28 February 2020

Dear Sir,
Application Ref: AW/22/20/HH – Proposed two storey side extension at 41 Aldwick Fields,
Bognor Regis

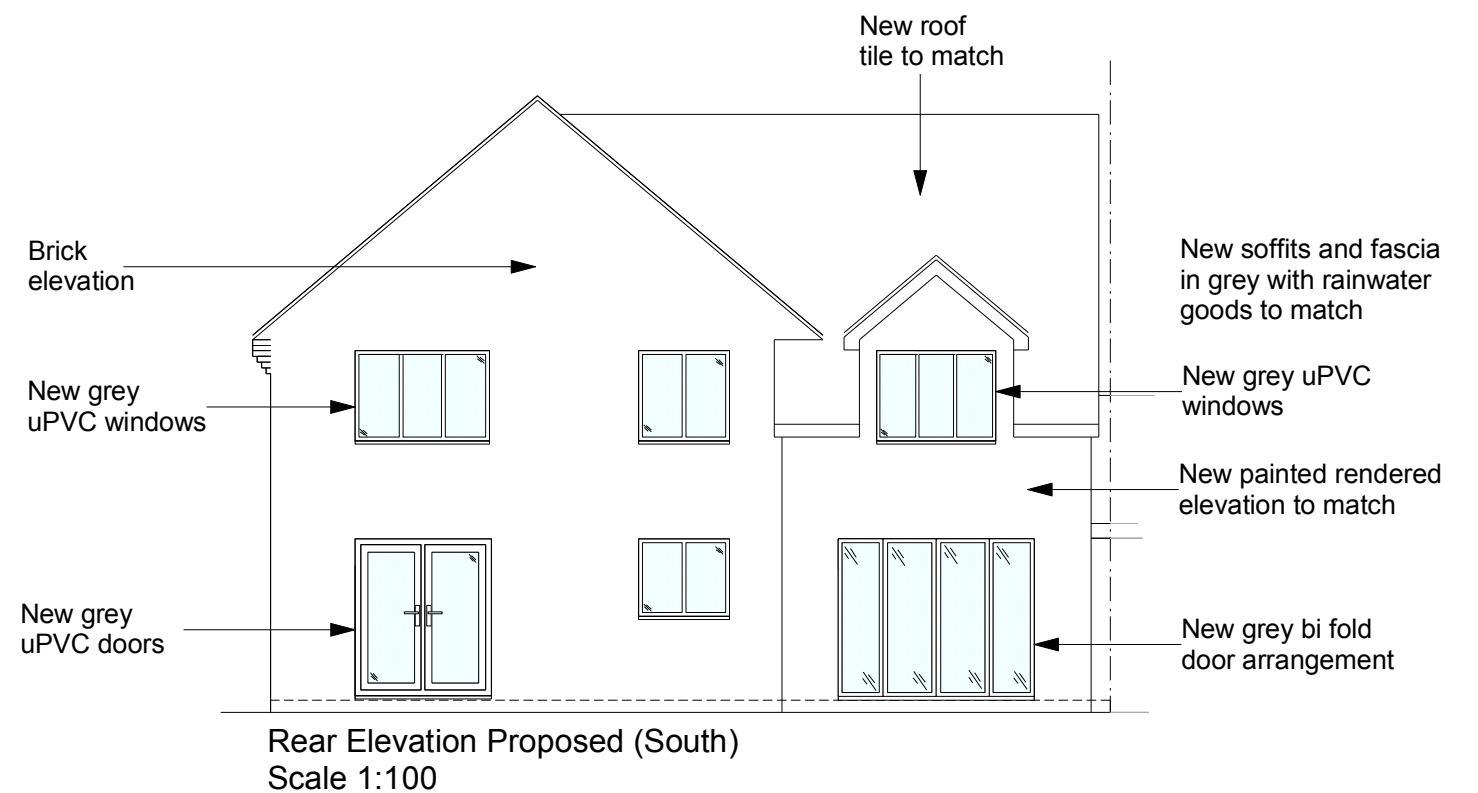
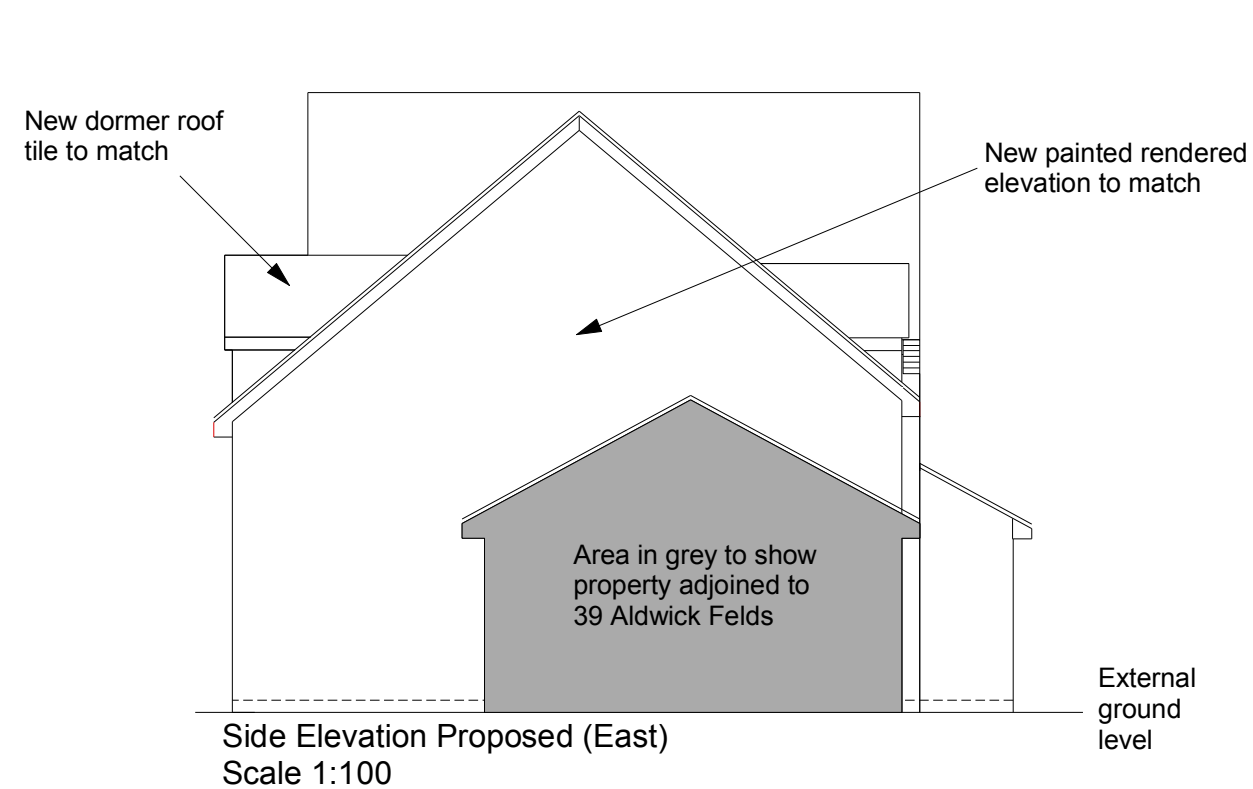
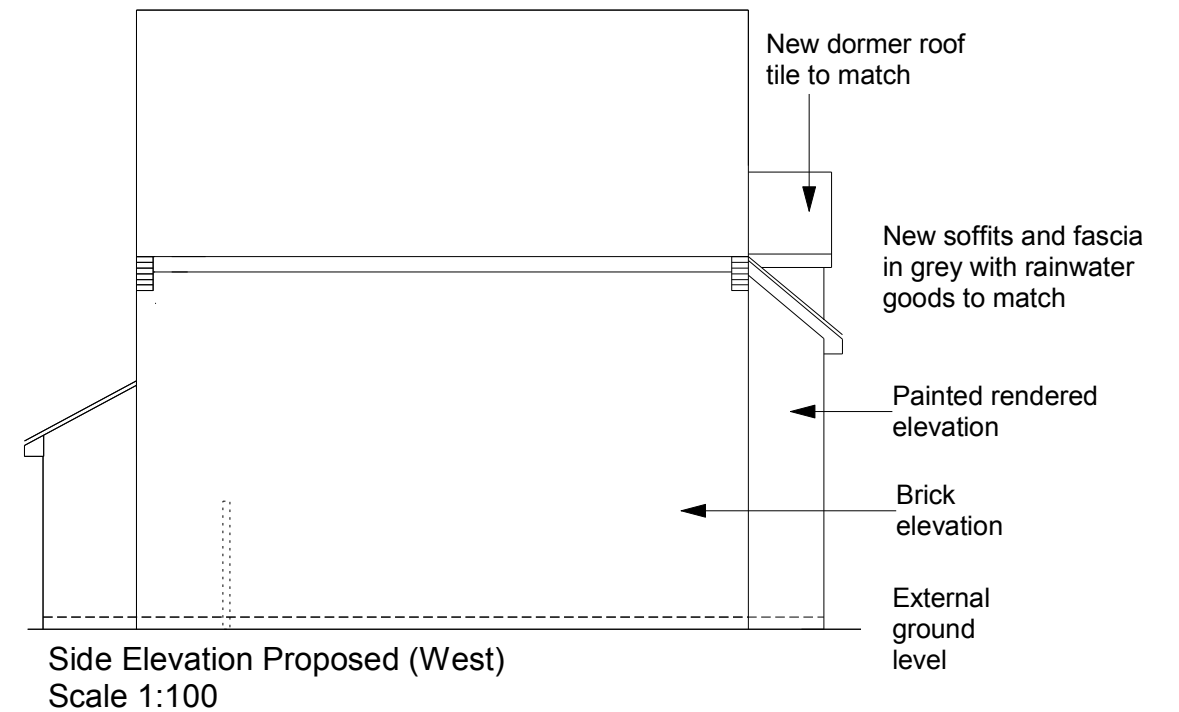
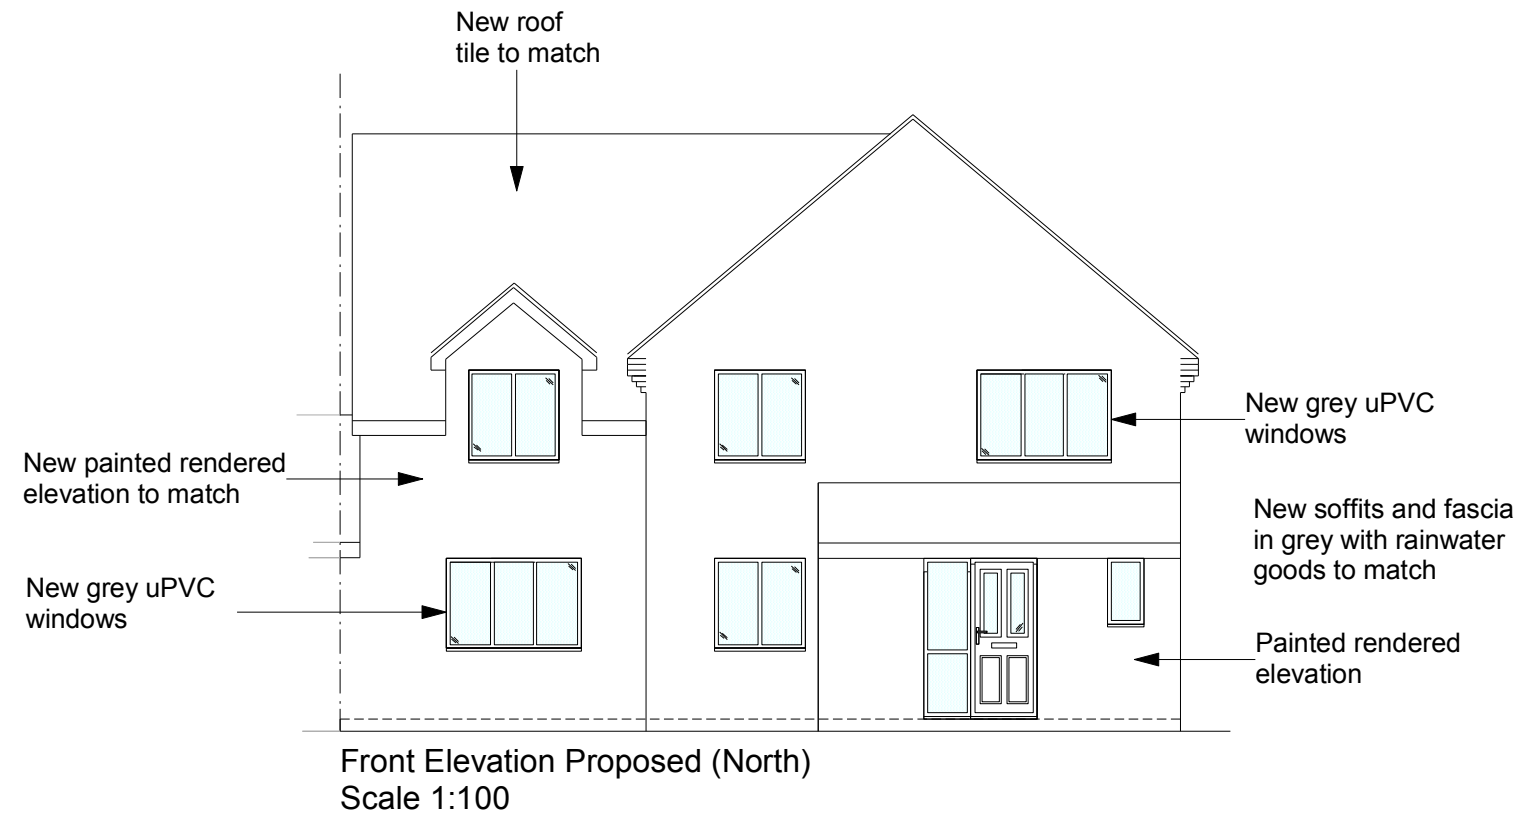
With reference to the above numbered planning application we wish to register our objection to this proposal on the grounds that the extension, if permitted and implemented in its present form, would have an oppressive, overbearing and overshadowing effect upon our property having regard to its height, depth and position on the common flank boundary. Moreover, it would have a dominating effect upon the appearance of the street scene.

We feel that this detrimental impact on our property could be reduced if the proposed gable ended roof were to be modified in the form of a hipped ended roof with a roof slope similar to the pitch of the front gable ended roof. Further, the overall height of the extension should be reduced so as to appear subservient to the existing roof of the dwelling. With these suggested modifications to the design the bulk and mass of the extension would also be more in keeping with the street scene and other dwellings in Aldwick Fields. Attached to this letter is a copy of the applicants drawing No. NS003, Revision A, on which we have shown in red our suggested revisions.

No windows or other openings shall be constructed in the east elevation of the extension which adjoins the side boundary with No. 39 Aldwick Fields without the prior permission of the District Planning Authority on an application in that behalf.
